From: Jack Karagoz [REDACTED] >
Sent: 21 July 2026 09:32
To: Simon Davis; Rebecca Hornsby
Subject: RE: WA/18/26/PL - Land off Arundel Road

We note that the LLFA have raised several points on our previous responses (attached), which are set out below along with our response to each point. If possible we would be happy to have a quick teams meeting with you and the LLFA to talk through the remaining points rather than going back and forth every few weeks. Is this something you might be able to arrange?

Drainage Plans and Calculations

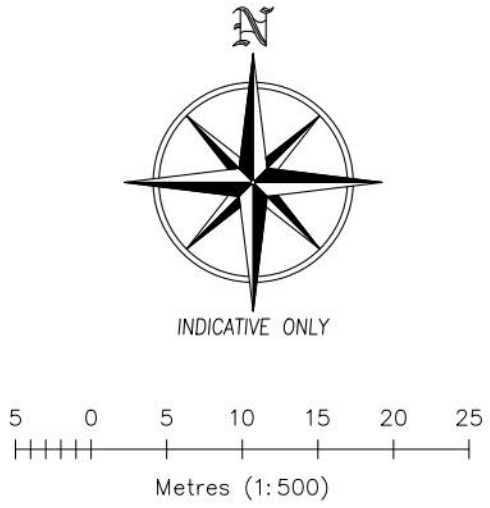
While infiltration is not being used to drain the site, there are several instances where the drainage strategy implies infiltration is still being used. For example, paragraphs 1.3.23 and 1.3.34 and the Contributing Areas Plan and Drainage Strategy Plan all still mention infiltration or infiltration basin. This does not accurately reflect how the site is proposed to drain. There may be other instances where this is an issue. It is also important that this is reflected in any other relevant document submitted under this application, to ensure documents are consistent.

The infiltration basin is still included in the Contributing Areas plan.

It is unclear whether the design of the attenuation basin has considered the high groundwater levels. We request a cross section of the basin and porous paving, to ensure groundwater is considered in the design of SuDS features.

This is not adequately addressed. Currently, the cross section shows that the base of the basin is where the highest groundwater level is located. There does not appear to be any evidence of how the groundwater has been considered in the design of the basin. It is important the capacity of the basin is not impacted by high groundwater levels, as flood risk could increase elsewhere.

It is unclear whether freeboard from the 1 in 100 year plus climate change event has been included in the basin design.

To ensure the application is in accordance with national planning policy and guidance, residual risk should be safely managed. There is currently 50mm between the maximum water level in the 1 in 100 plus climate change event (design event). There does not appear to be any plans showing finished floor levels. This therefore means the residual risk if the capacity of the basin and associated infrastructure were exceeded has not been adequately addressed.

A minimum 3m easement for the attenuation basin is required, for maintenance access.

The easement shall go around the entire basin, rather than part of it. For the side near the building, it is unclear whether the basin can be safely maintained. As these issues could affect the layout and scale of the site, it would not be reasonable for the above to be covered via conditions at this stage

We don't understand this point. Could clarification be provided.

The groundwater monitoring results were shown in the FRA. The pond was in the location where the groundwater was at its lowest through the winter testing. This was at a depth of 1.5m BGL. Given a ground level of 31.6m AOD, the maximum groundwater level can therefore be seen to be 30.10m AOD. This coincides with the base of the pond so will not affect the capacity of the lined pond.

Levels are shown on the drainage plan. Additional levels have been shown on the adjacent dwellings which indicate a maximum freeboard of 0.3 above the 1 in 100 year plus climate change level.

We have currently shown a 3m easement for maintenance for the inlet and outlet structures. Any other maintenance can be carried out from within the basin.

Notwithstanding the above we can tweak the layout to provide the 3m easement around the entire perimeter as below.
